Department of Planning and Environment

Our ref: SSD-31552370

Subject: Raymond Avenue Warehouse, Matraville (SSD-315523370) Request for Additional Information

Attachment 1 Department of Planning and Environment Comments on EIS

Figure 4 Modelled Source Locations

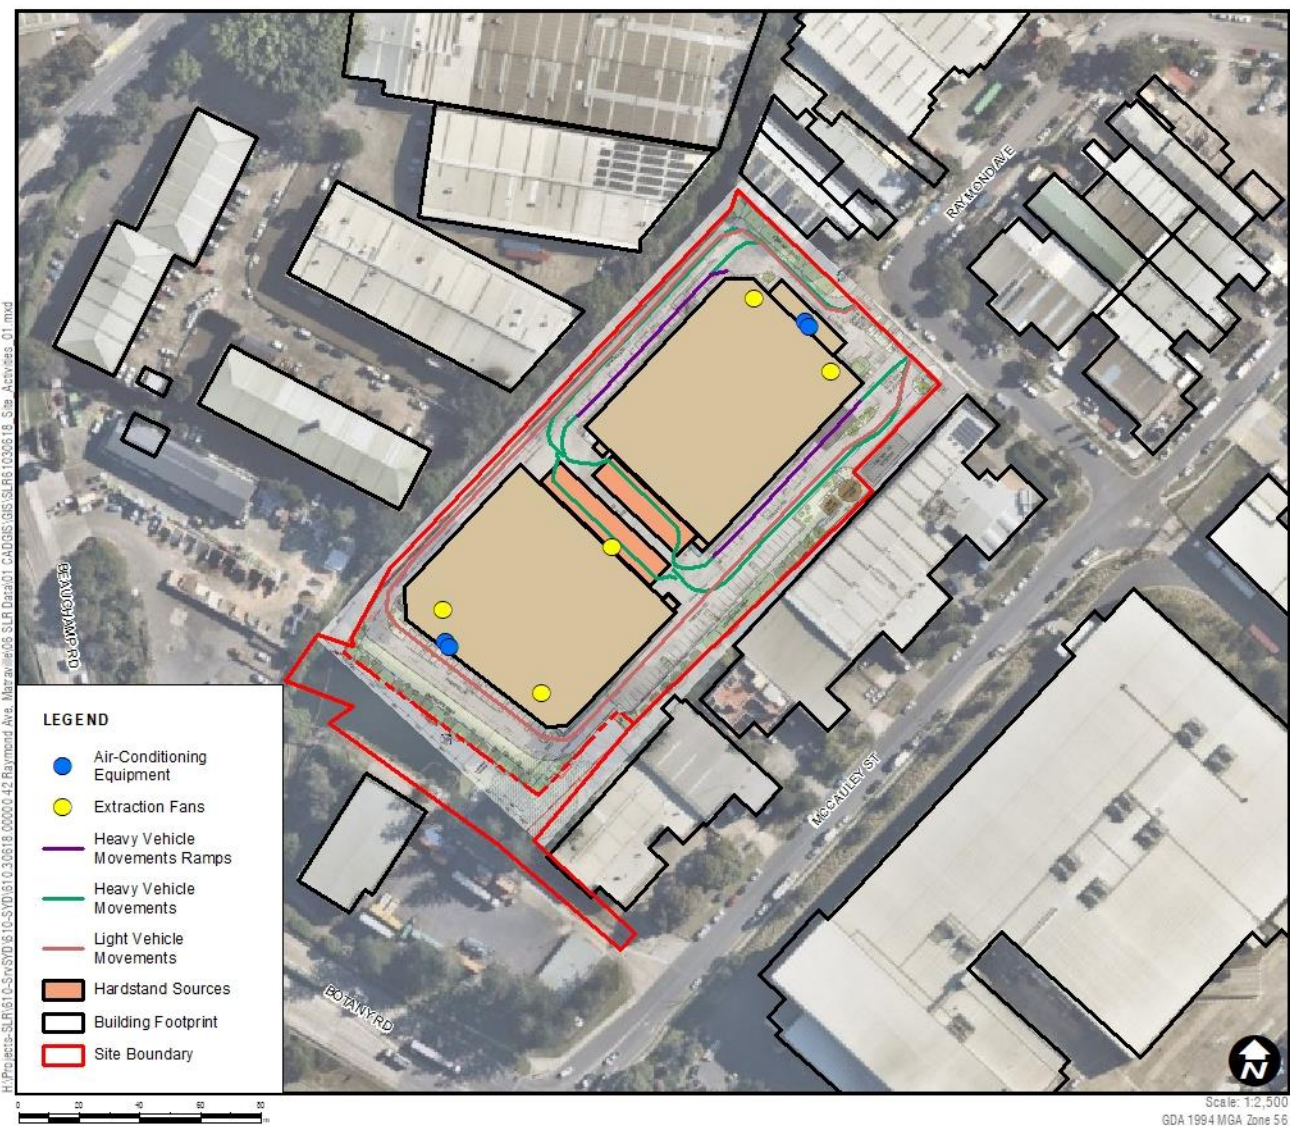
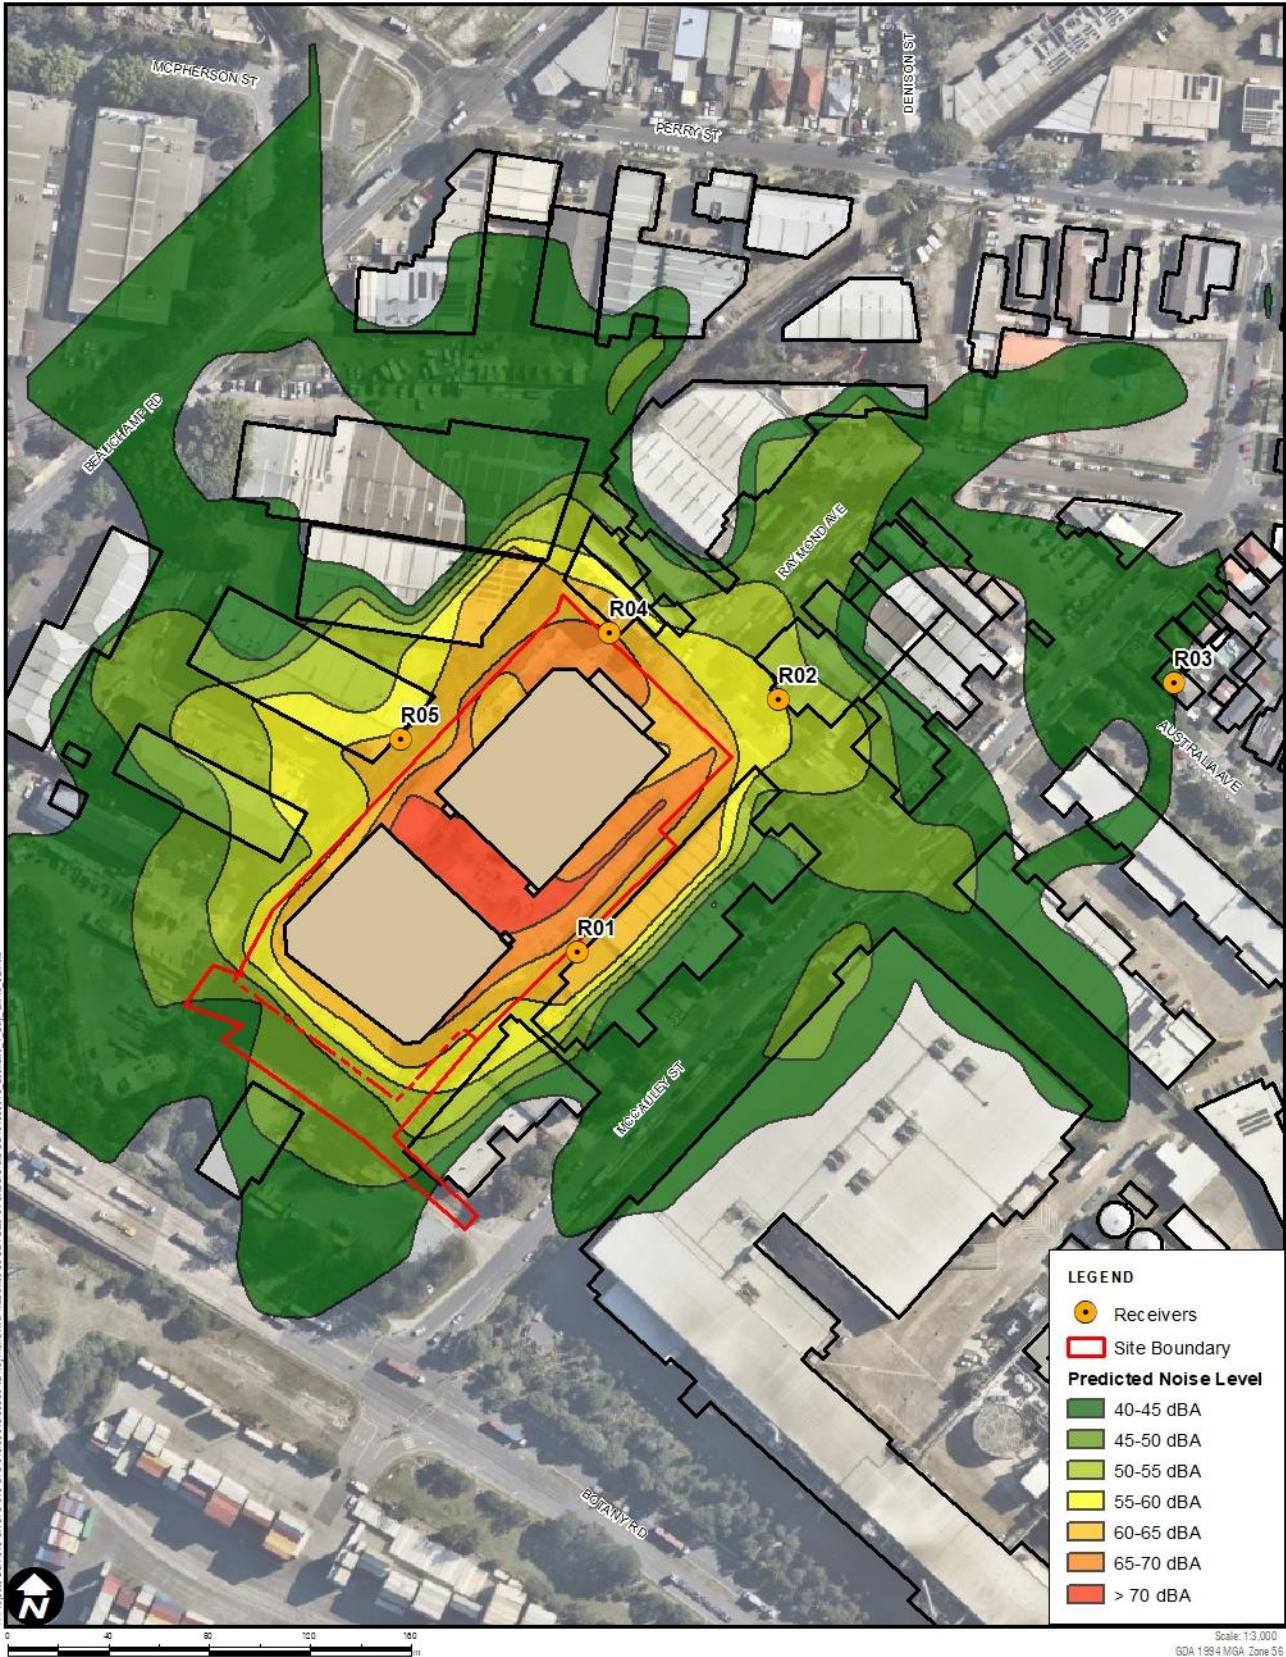
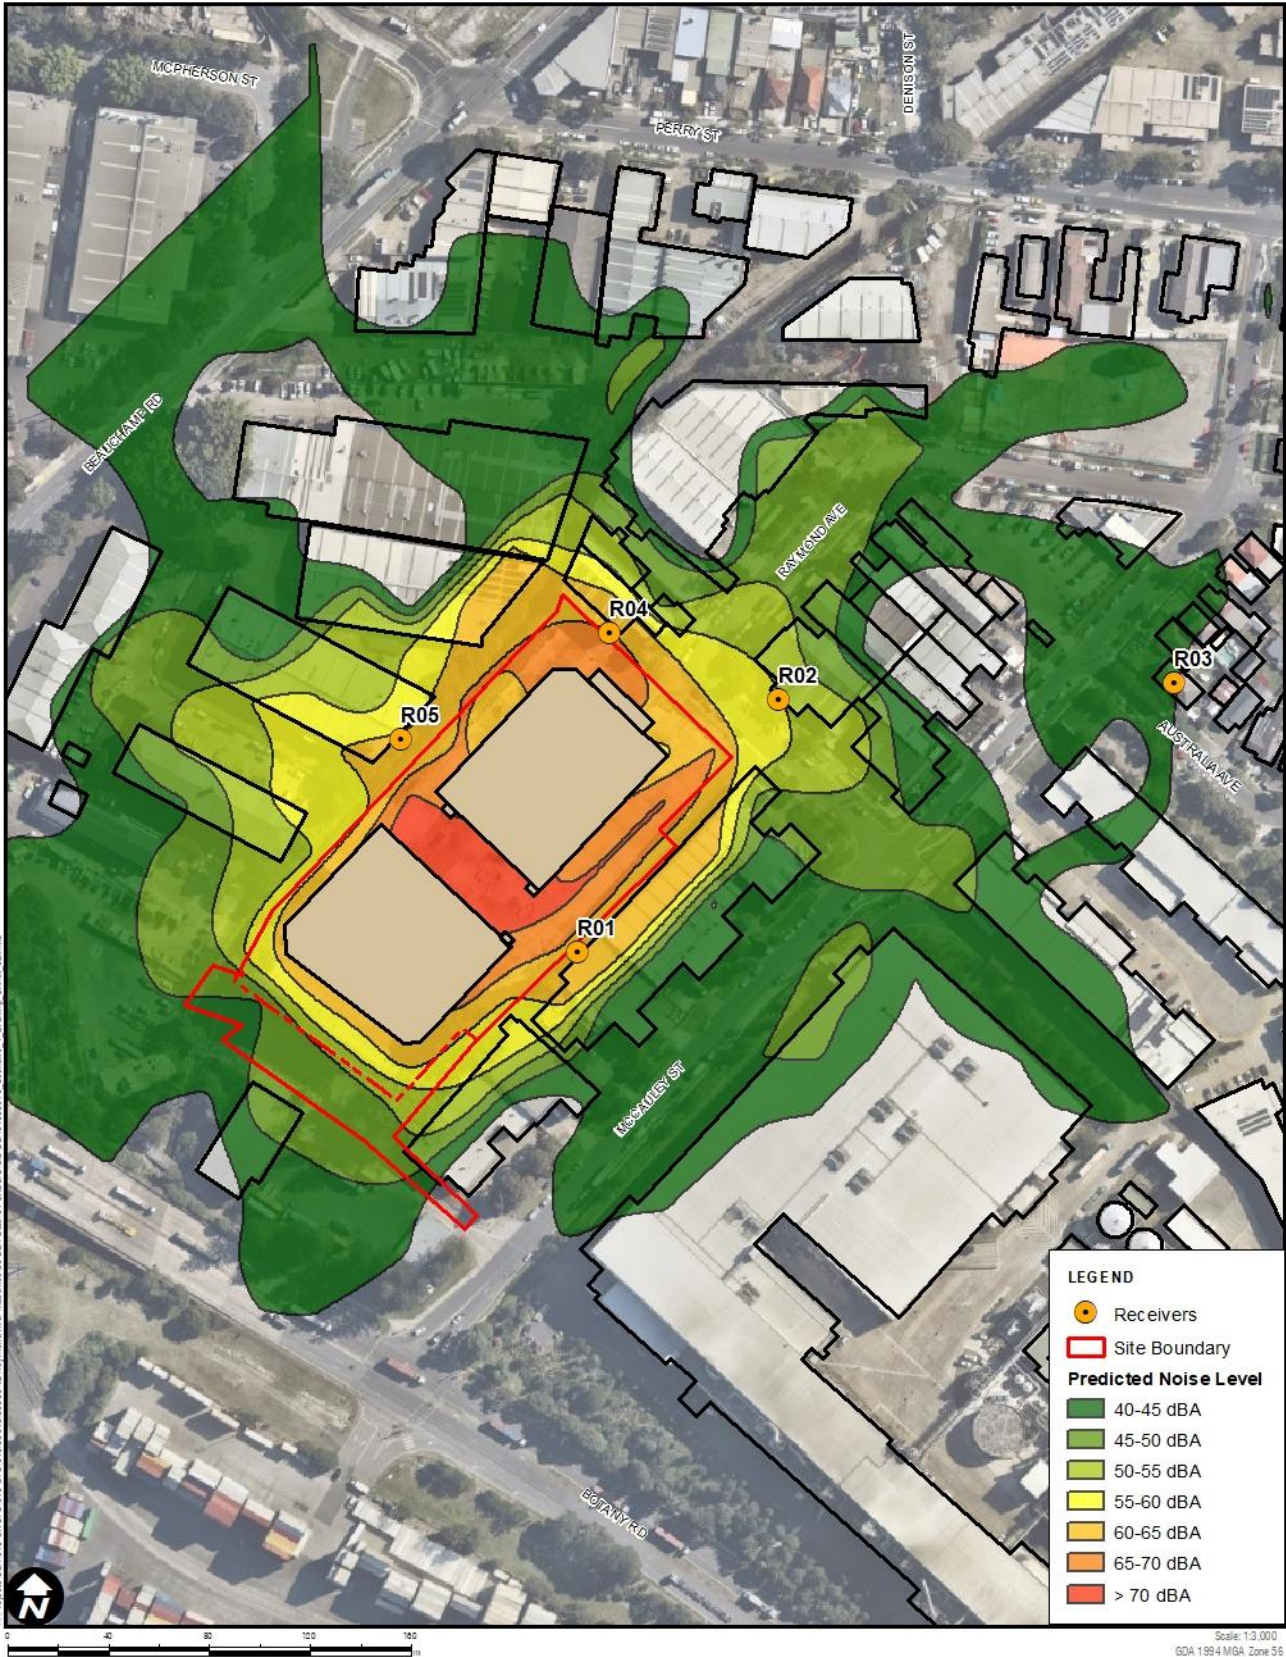
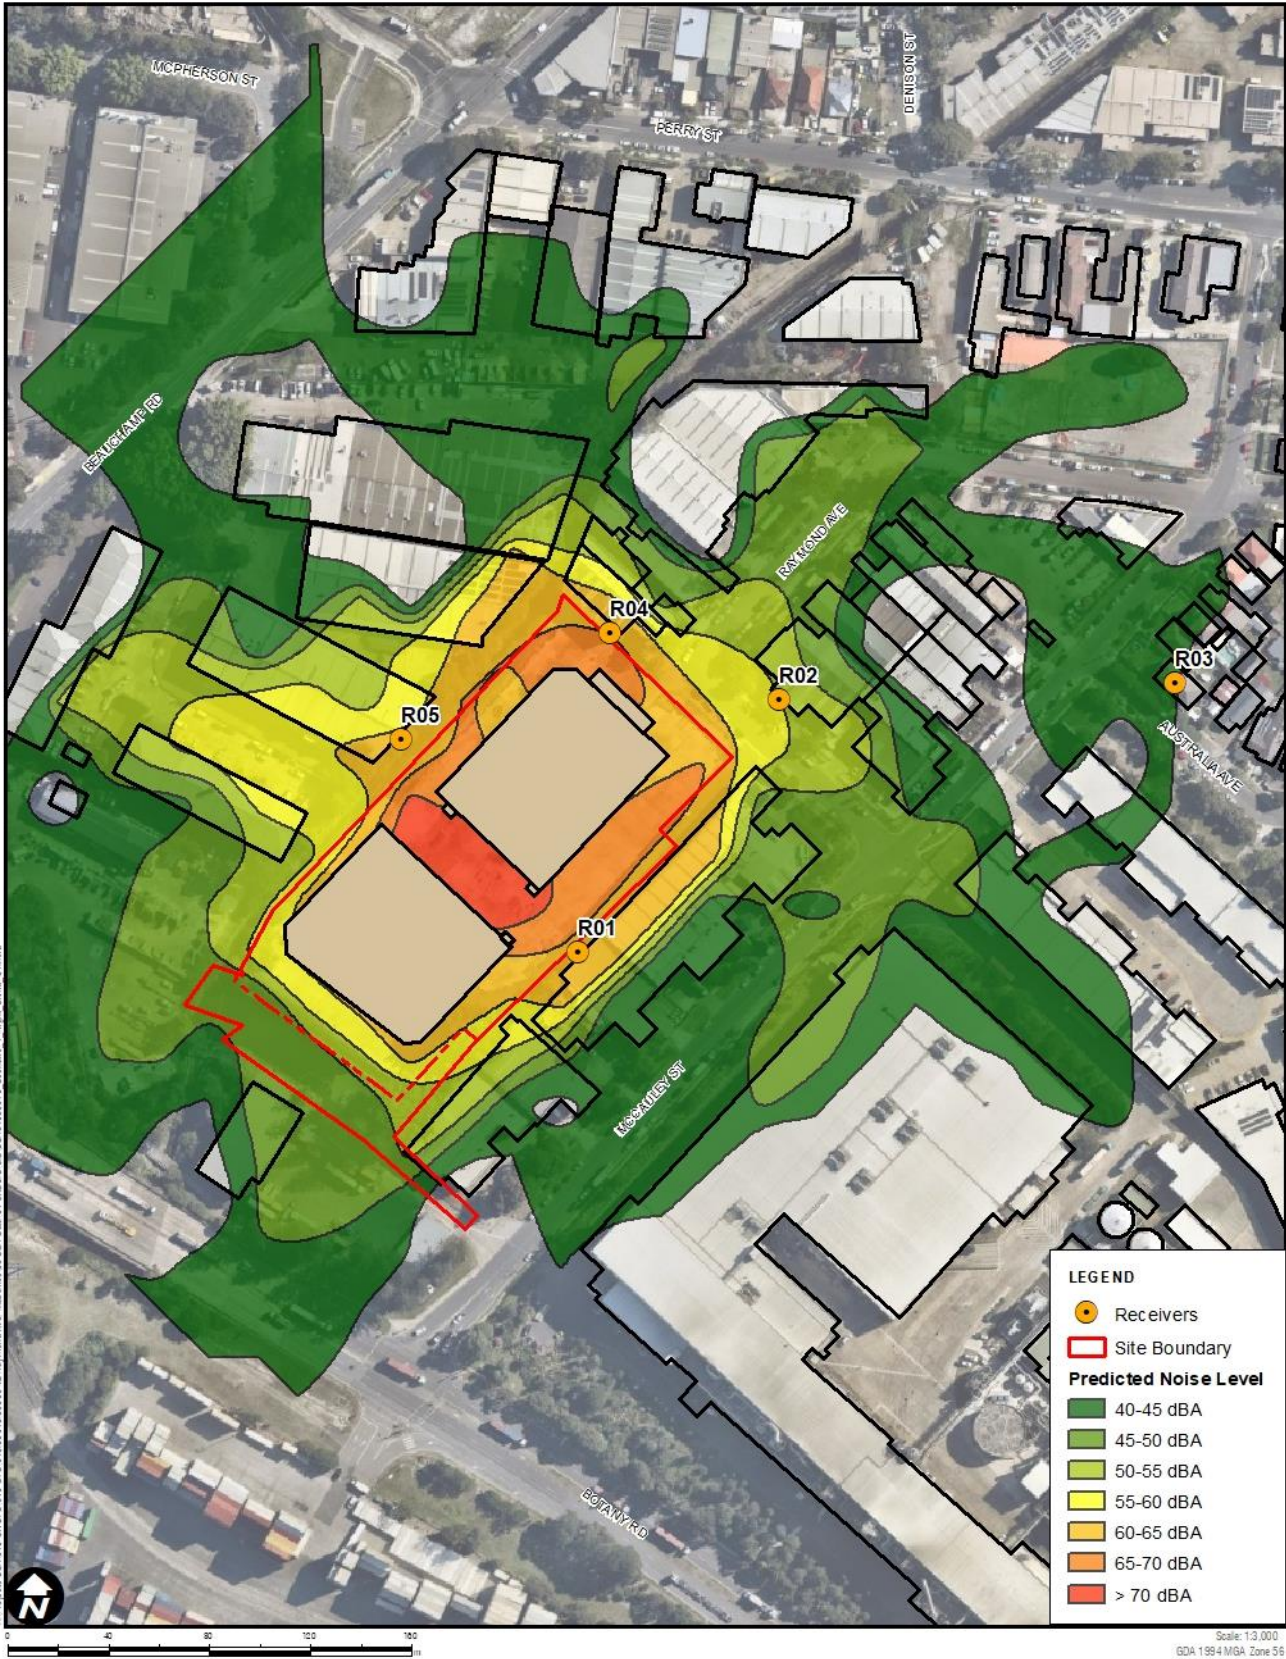
10. The potential increase in traffic noise is cited as a source of noise concern by residents living in close proximity to the subject site. The TIA details night-time exceedance for receiver R03 caused by a combination of noise from the roof mounted fans, on-site truck movements (hardstand) and loading activities. Further clarification is required to verify if the accelerating and decelerating articulated vehicles and small rigid trucks, as they utilise the key access ramps to level one, have been included as a night-time source.
11. Additionally, feasible and reasonable noise mitigation measures such as at-property treatments along the access ramps may be required to minimise night-time noise impacts.
